The Sizewell C Project

**Natural England's Comments on the Permanent and Temporary Beach
Landing Facility and SSSI Crossing Plans**

Planning Inspectorate Reference: EN010012

24th September 2021

DRAWING NO:
SZC-SZ0100-XX-000-DRW-100207

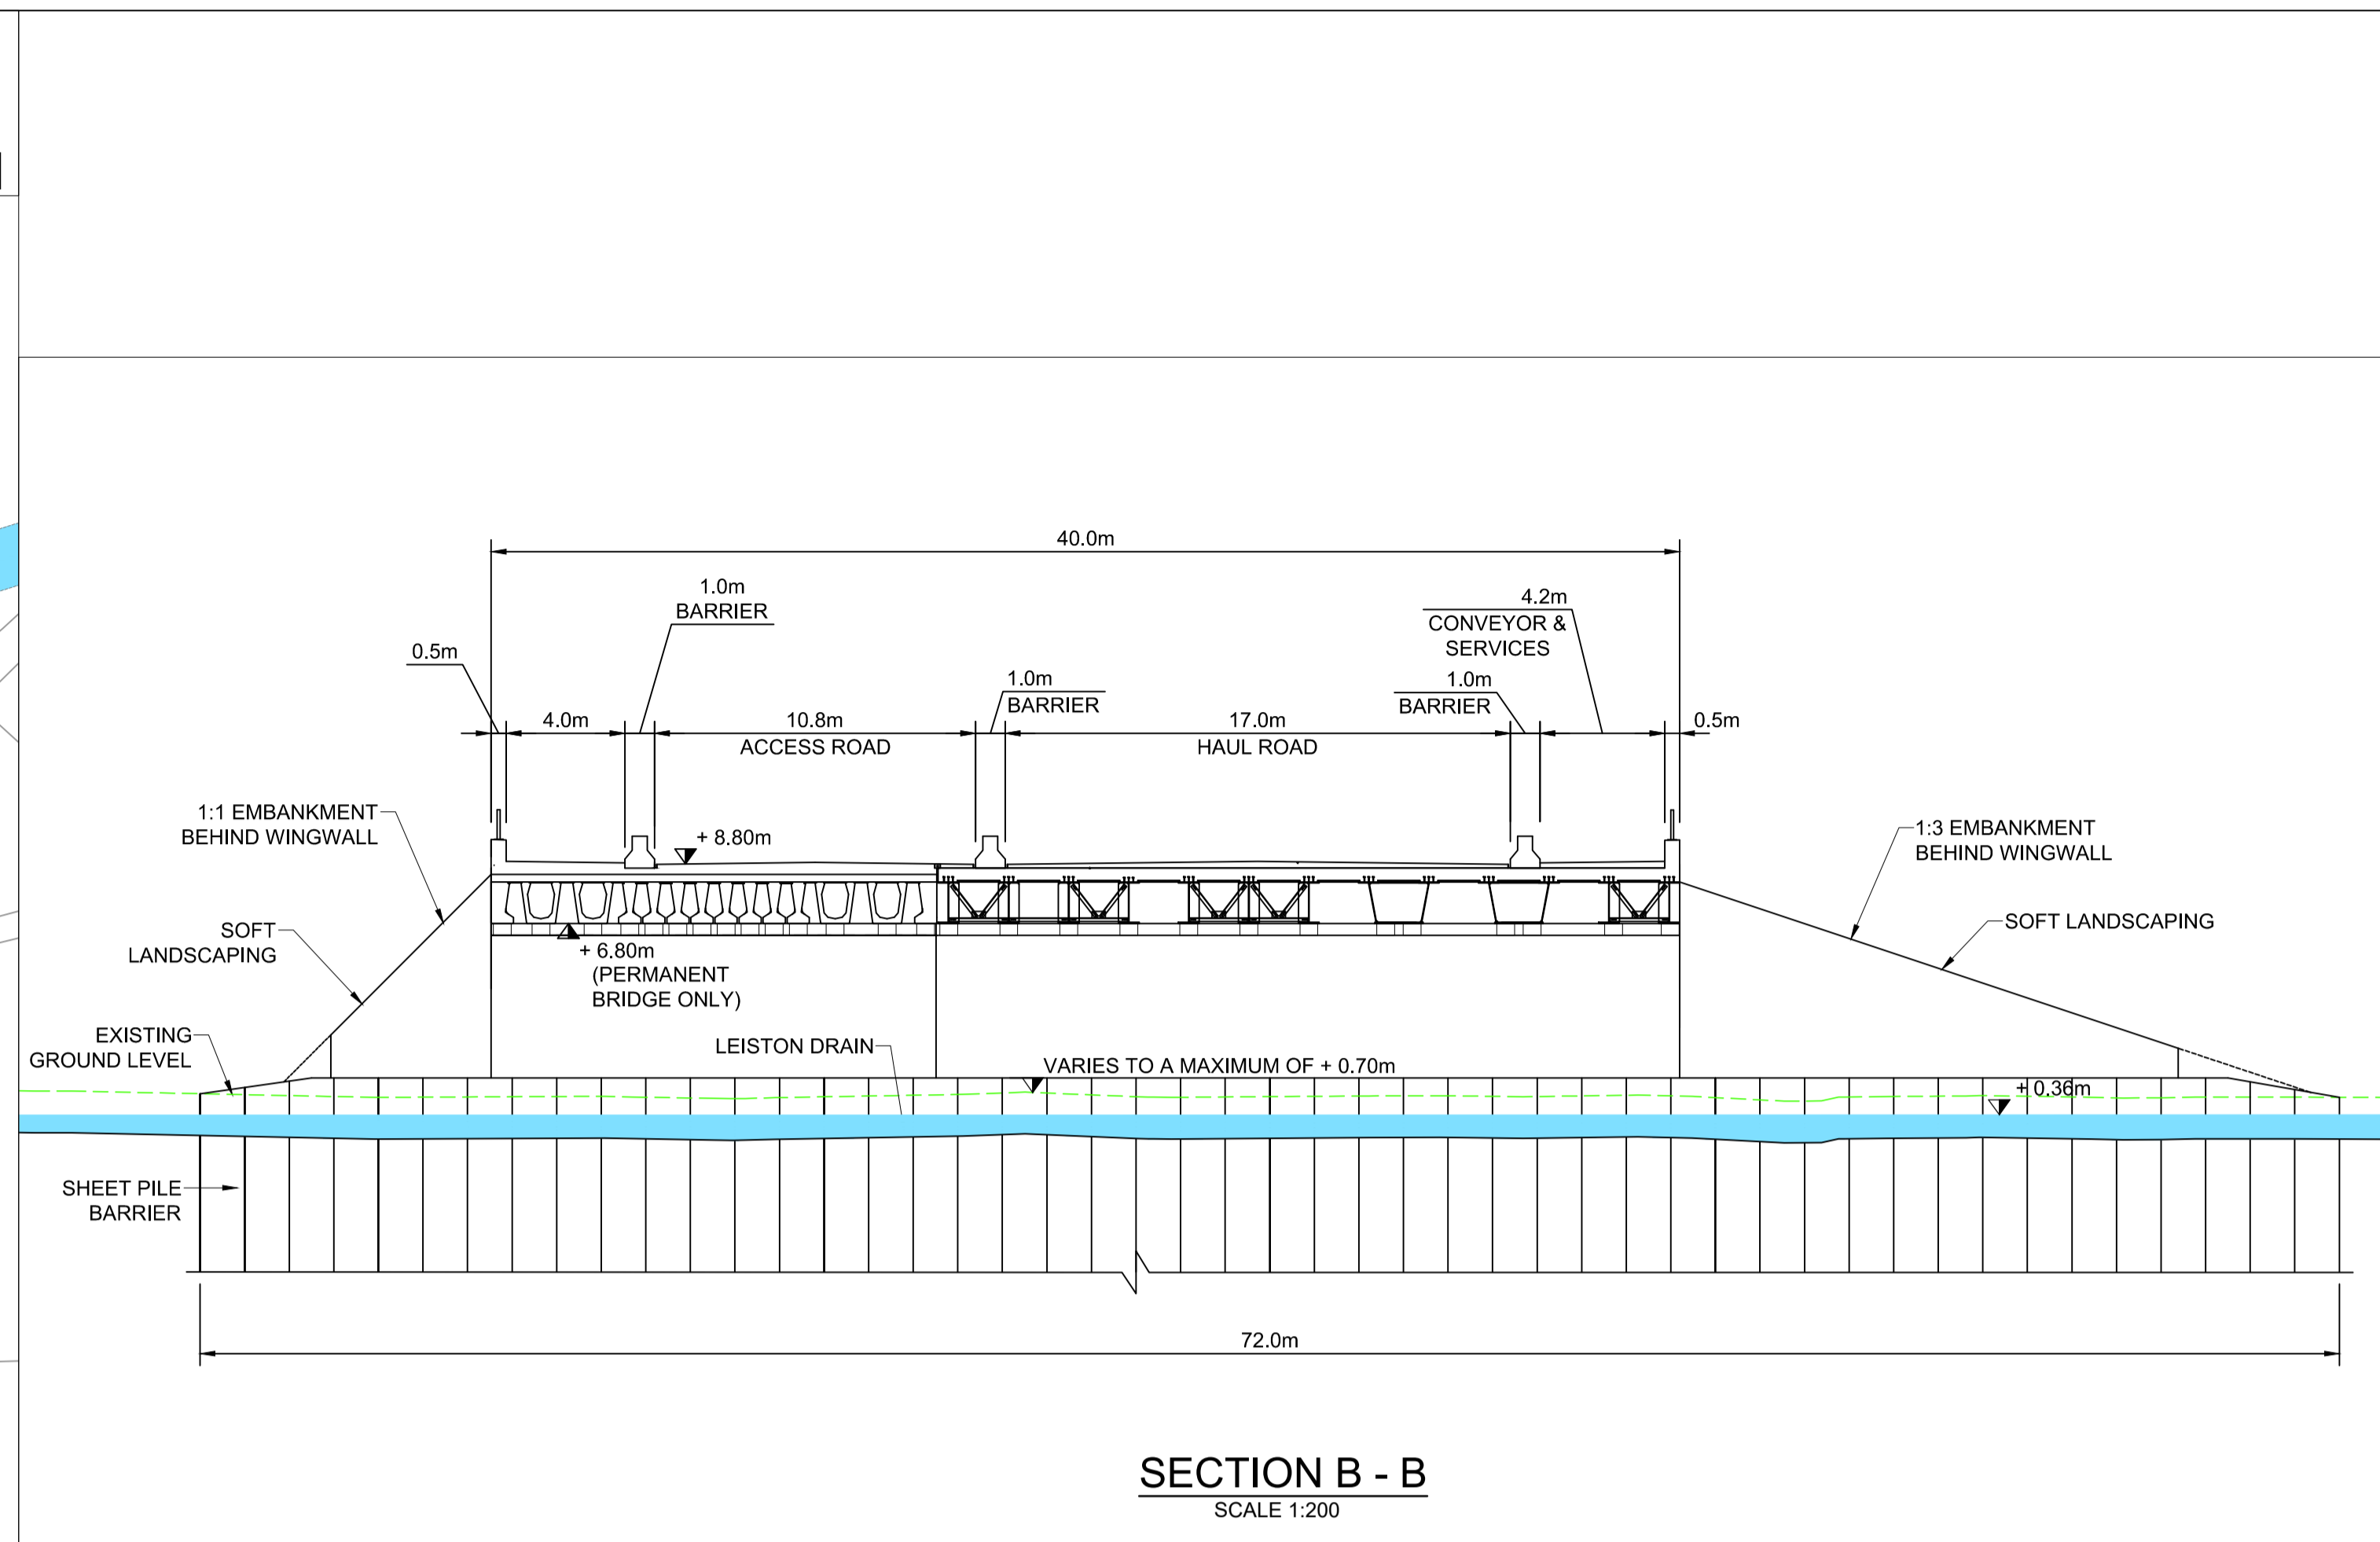
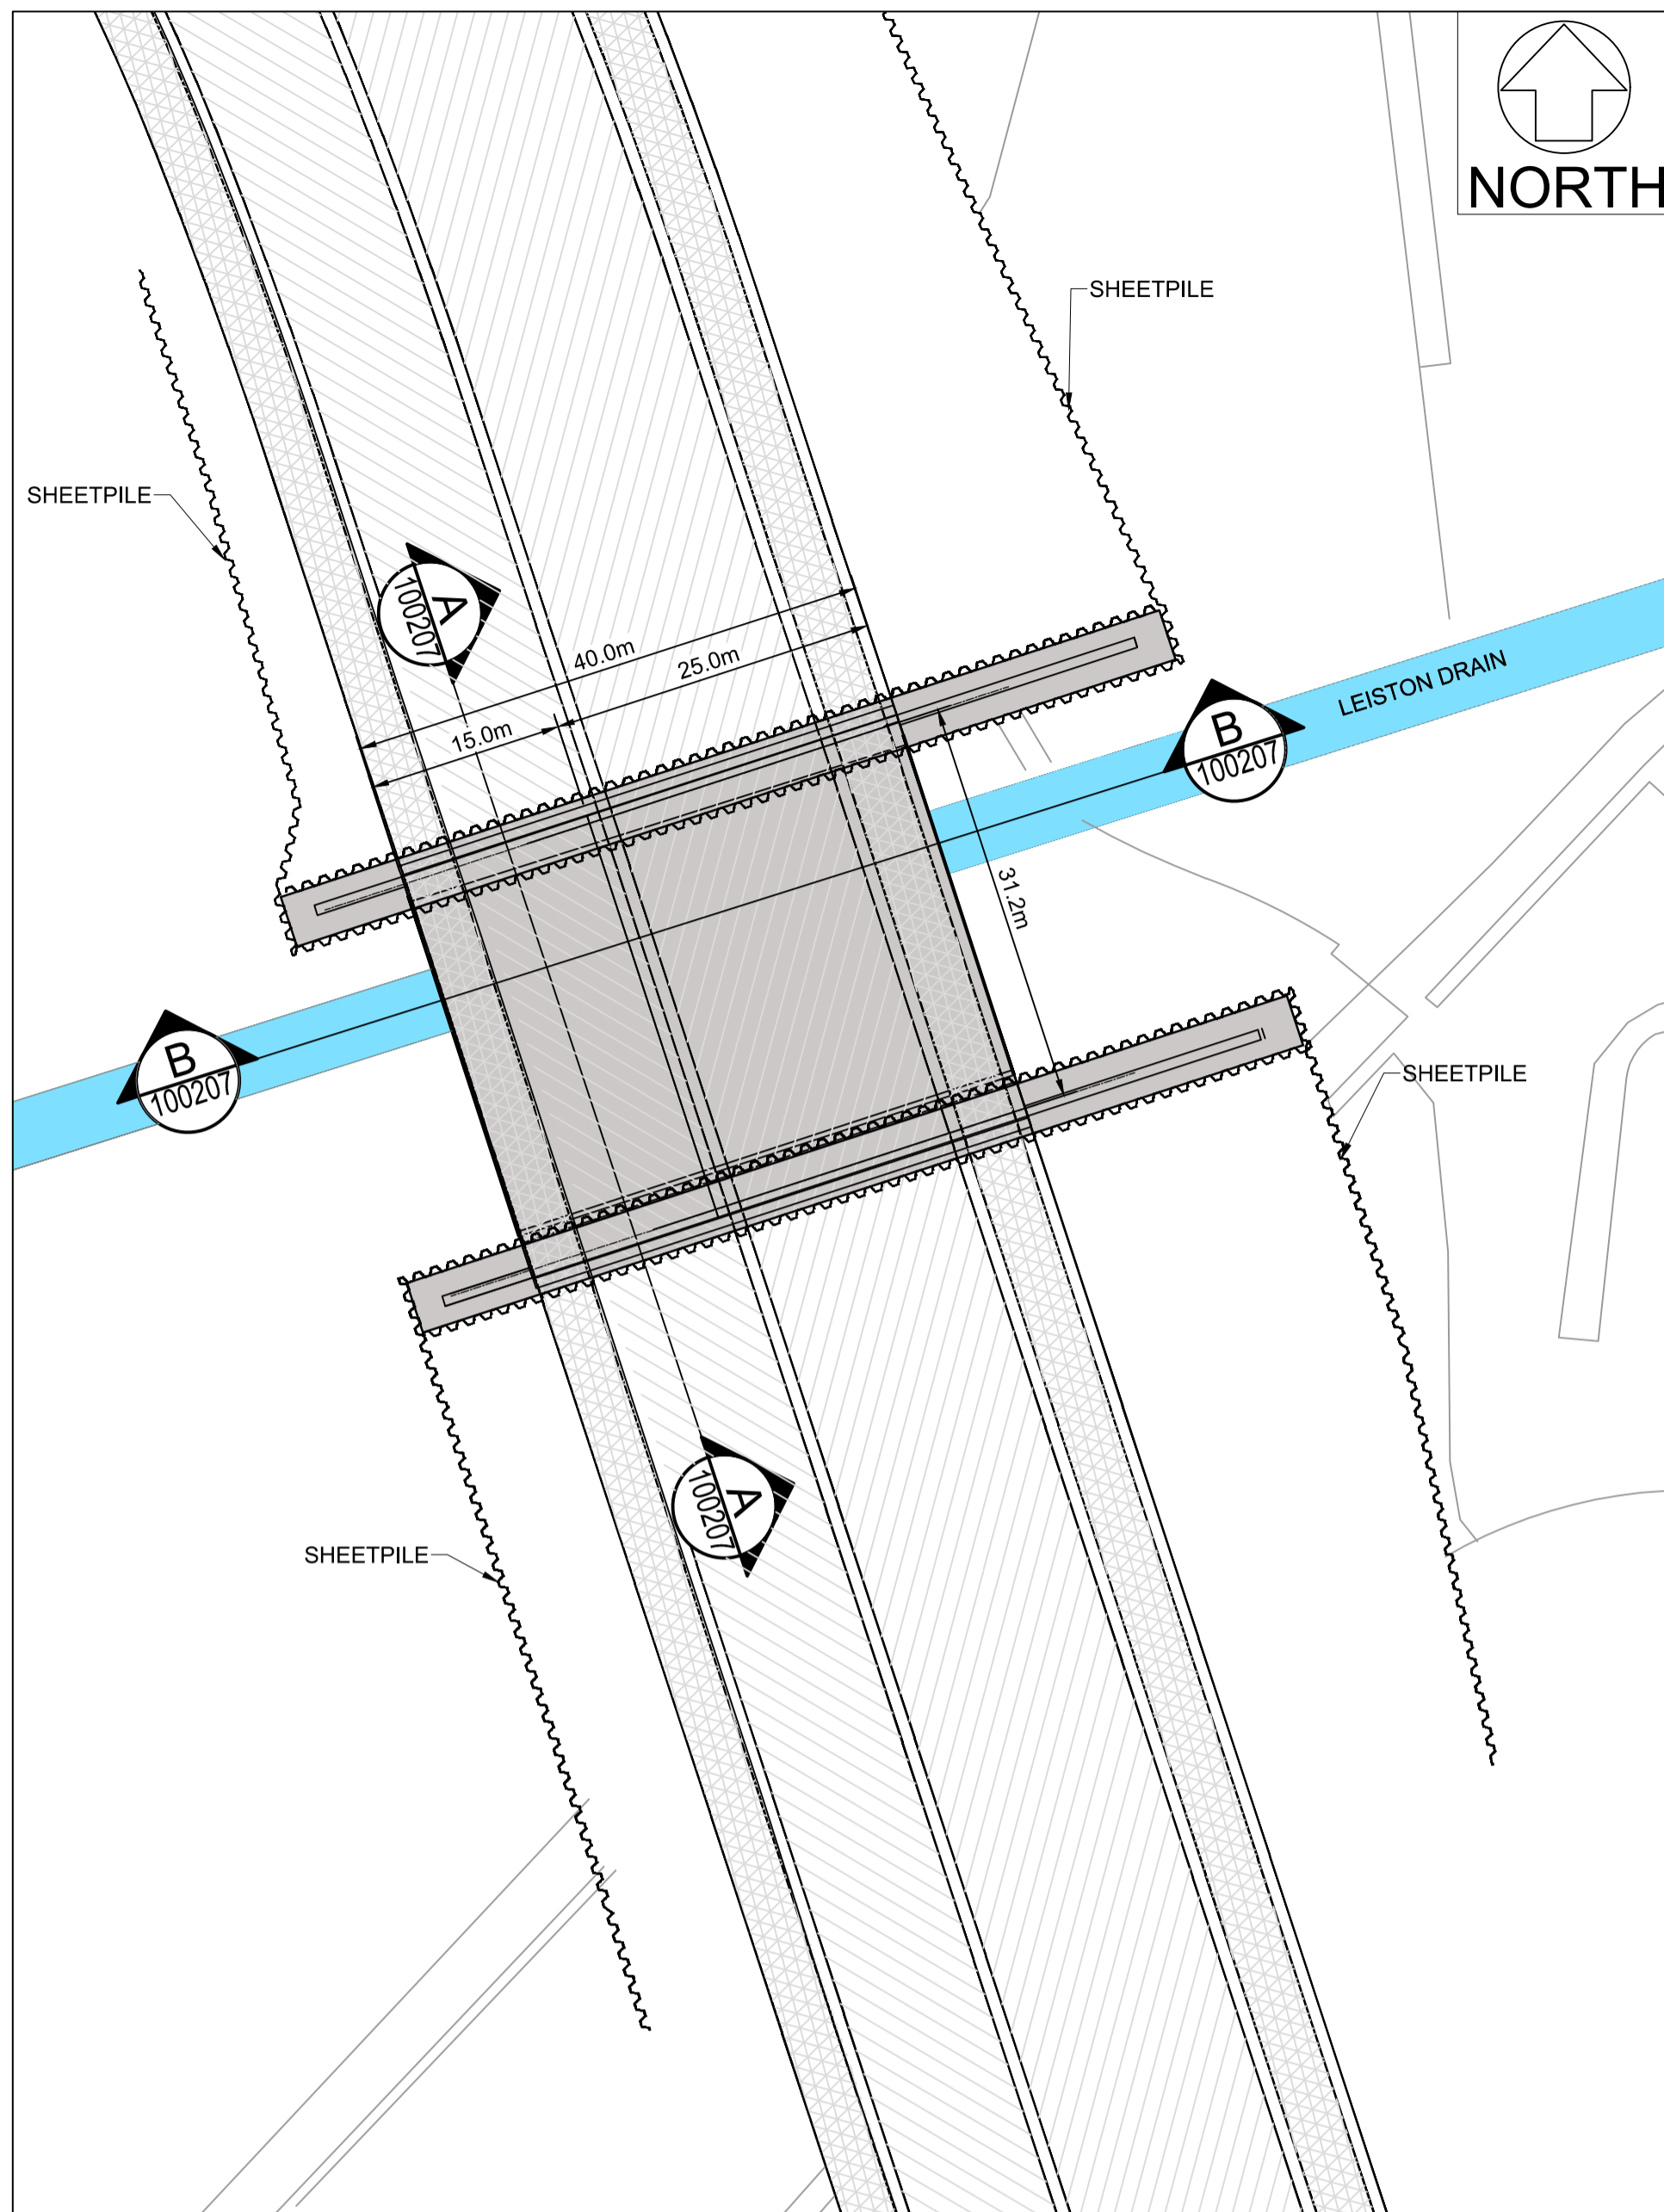
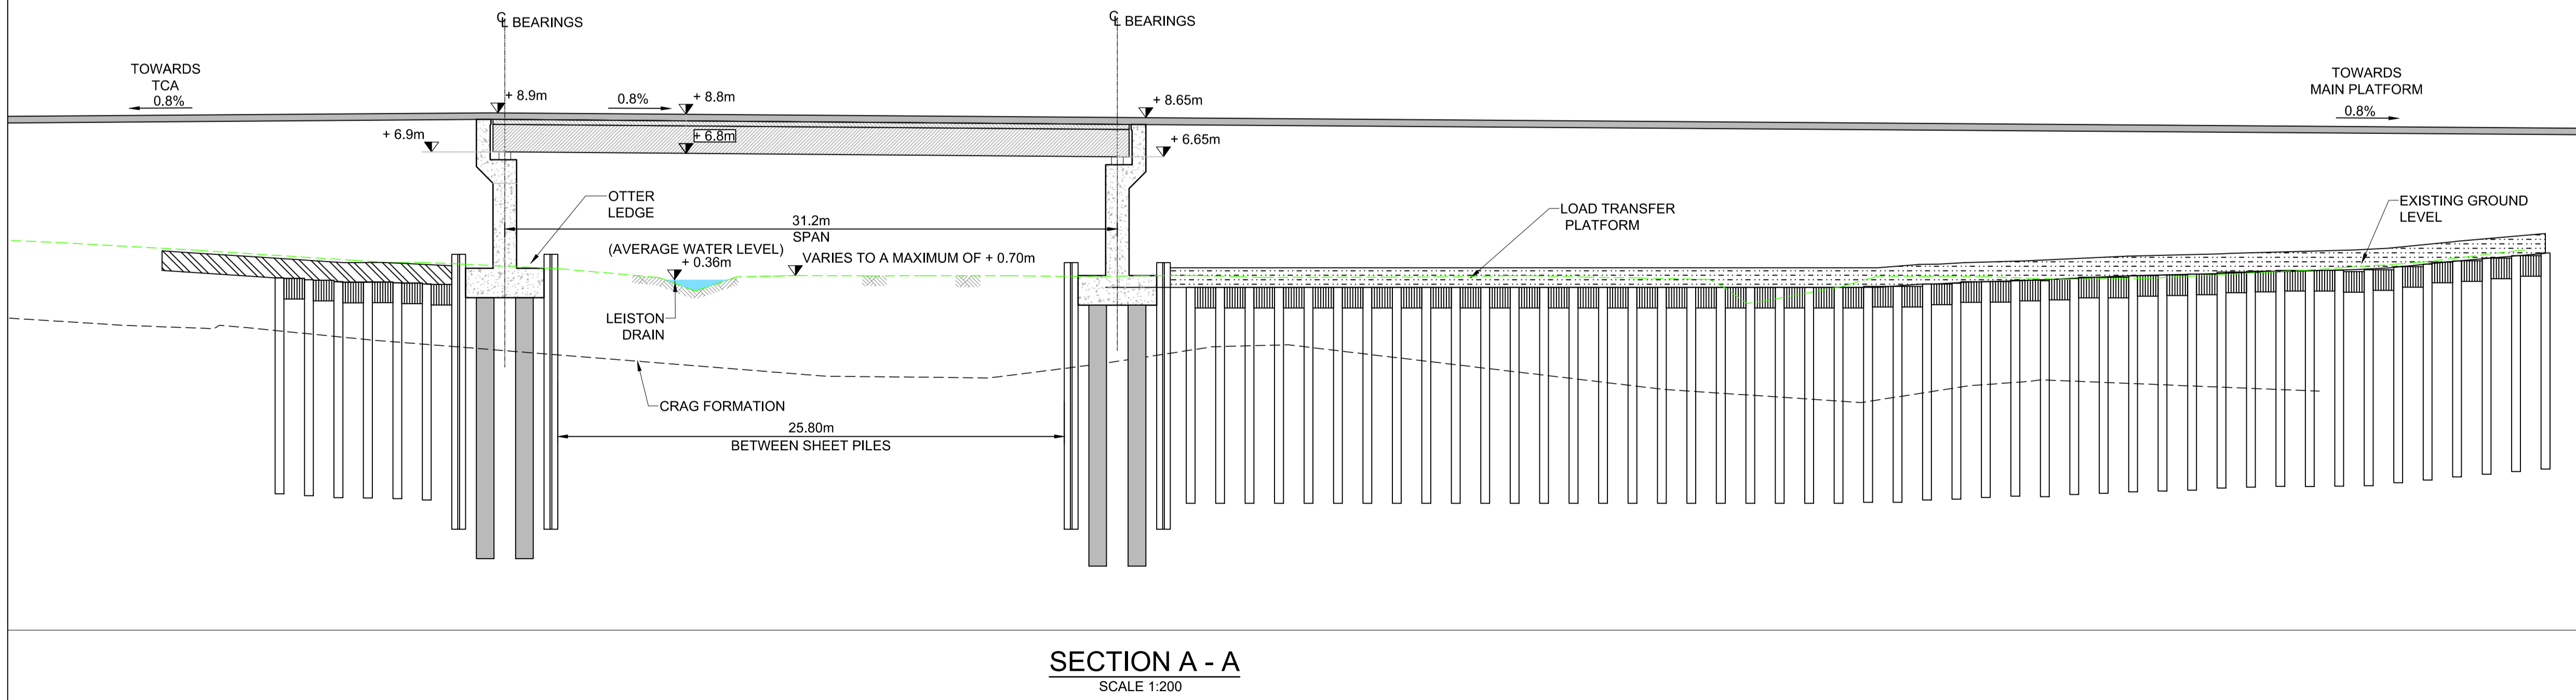
- 1.2 We welcome the continued optimisation of the SSSI crossing design which features a hybrid culvert and free-span bridge. Natural England acknowledges that the Applicant has taken steps to improve the SSSI crossings design to raise soffit height and reduce width post-construction to improve dispersal of invertebrates.

- 1.3 We understand that the preference for this design option by the applicant is based on the construction timetable (a three-span bridge would potentially take longer to build). We believe that the current iteration of the hybrid culvert and free-span bridge design is as optimal as possible within the limits of this design option. Should the examining authority consider this reasoning justifiable we believe that the current hybrid culvert and free-span bridge design represents a best alternative.
